**EL PASO COUNTY PLANNING AND  
 COMMUNITY DEVELOPMENT  
 DEPARTMENT**

**GRADING AND EROSION CONTROL PLAN CHECKLIST**

SHEET 2 OF 5

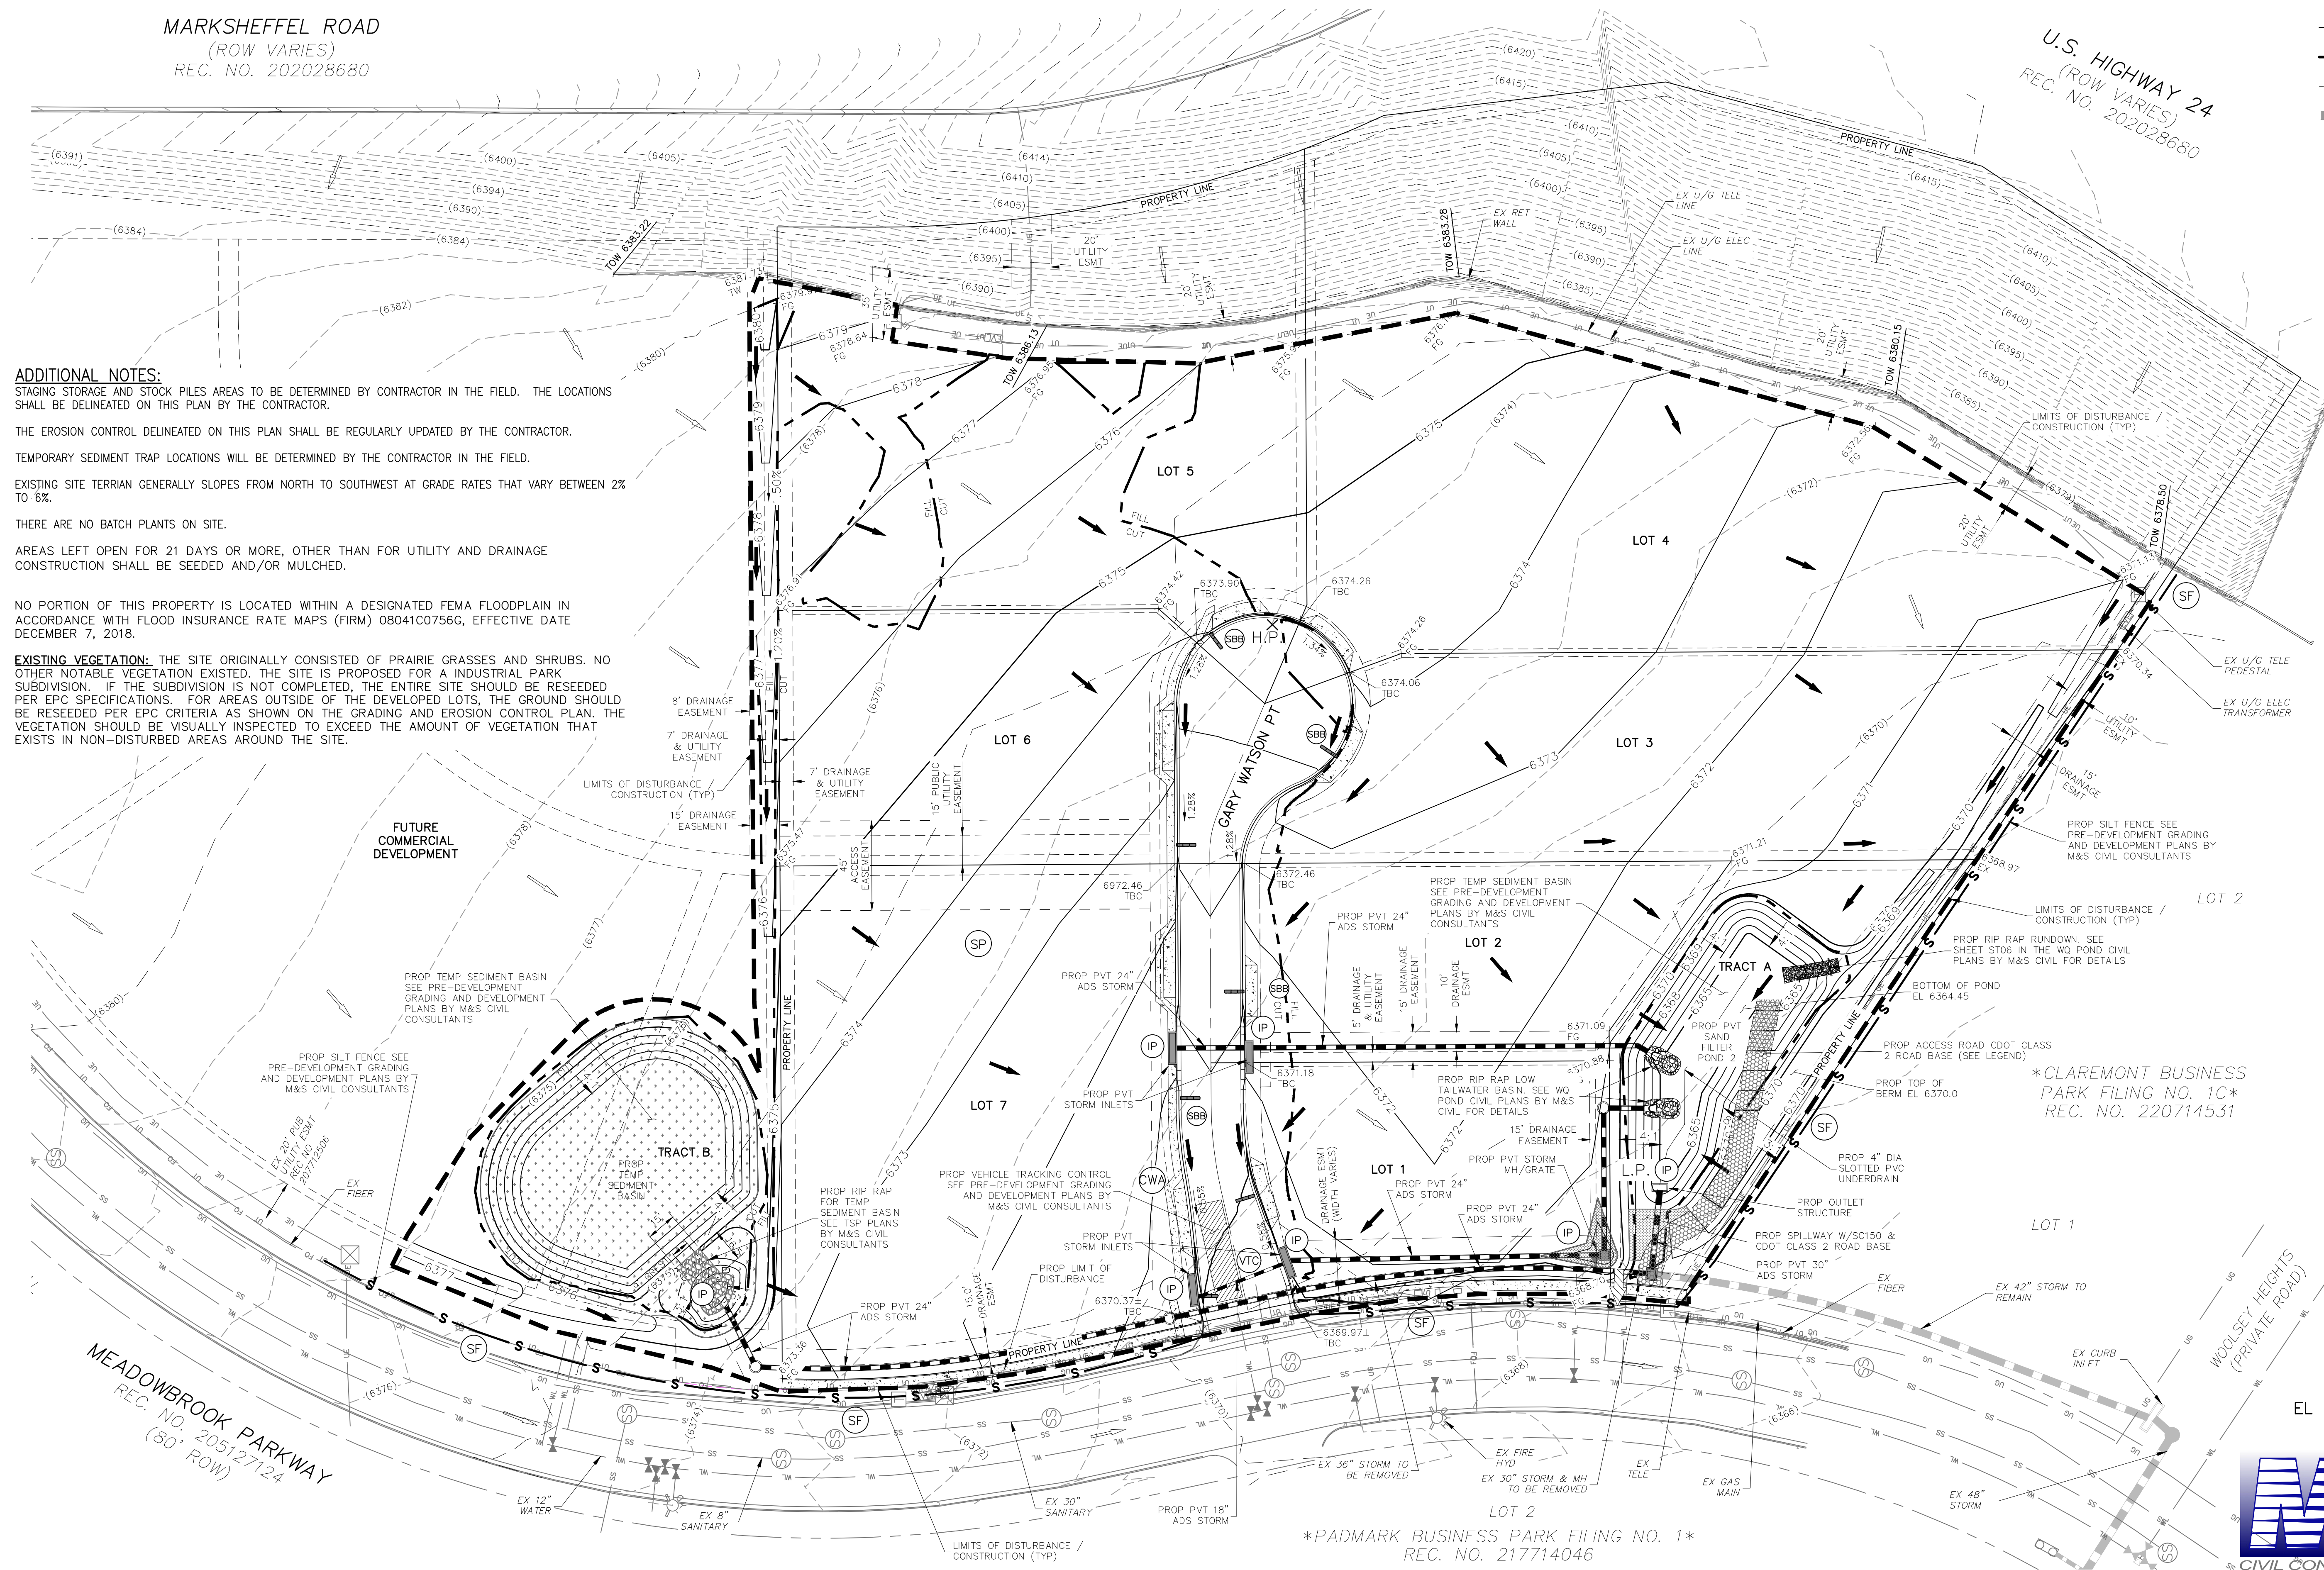
r	Proposed slopes steeper than 3:1 with top and toe of slope delineated. Erosion control blanketing or other protective covering required. slopes >3:1 not seen on site	X	N/A
s	Stormwater flow direction arrows. 3:1 slope is shown near the north Temp Sediment Pond	X	✓
t	Location of any dedicated asphalt / concrete batch plants.	N/A	N/A
u	Areas used for staging, storage of building materials, soils (stockpiles) or wastes. The use of construction office trailers requires PCD permitting. details on the Pre-Dev plan revised providing initial measures	X	✓
v	All proposed temporary construction control measures, structural and non-structural. Temporary construction control measures shall be identified by phase of implementation to include "initial," "interim," and "final" or shown on separate phased maps identifying each phase. See comments on Sheet 2 of GEC Plans	X	X
w	Vehicle tracking provided at all construction entrances/exits. Construction fencing, barricades, and/or signage provided at access points not to be used for construction. (2) temp Sediment pods have been provided	X	✓

VTC-1. AGGREGATE VEHICLE TRACKING CONTROL

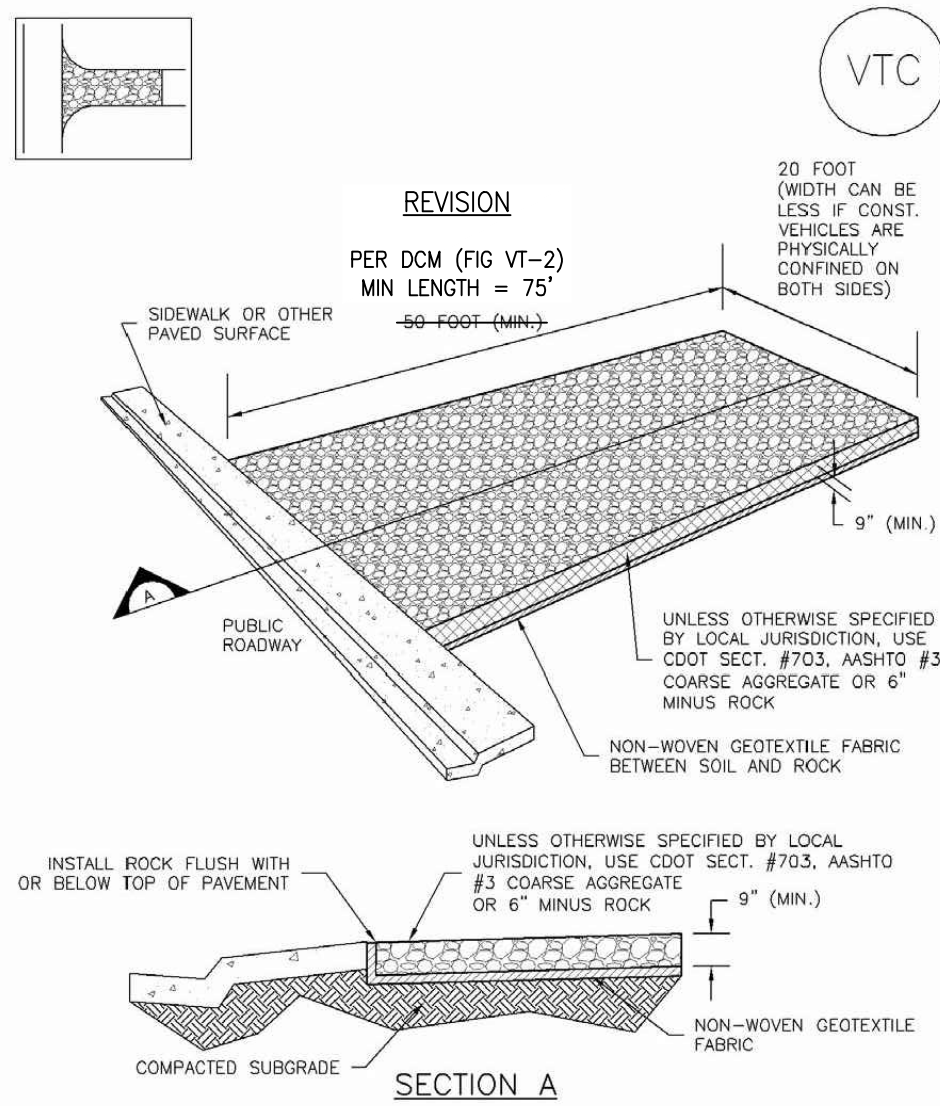
x	Temporary sediment ponds provided for disturbed drainage areas greater than 1 acre.	X	X
y	Dewatering operations to include locations of diversion, pump and discharge(s) as anticipated at time of design.	N/A	N/A
z	All proposed temporary construction control measure details. Custom or other jurisdiction's details used must meet or exceed EPC standards. See comments on Sheet 2 & 3 of GEC Plans	X	X

VTC detail modified to meet the El Paso County standards
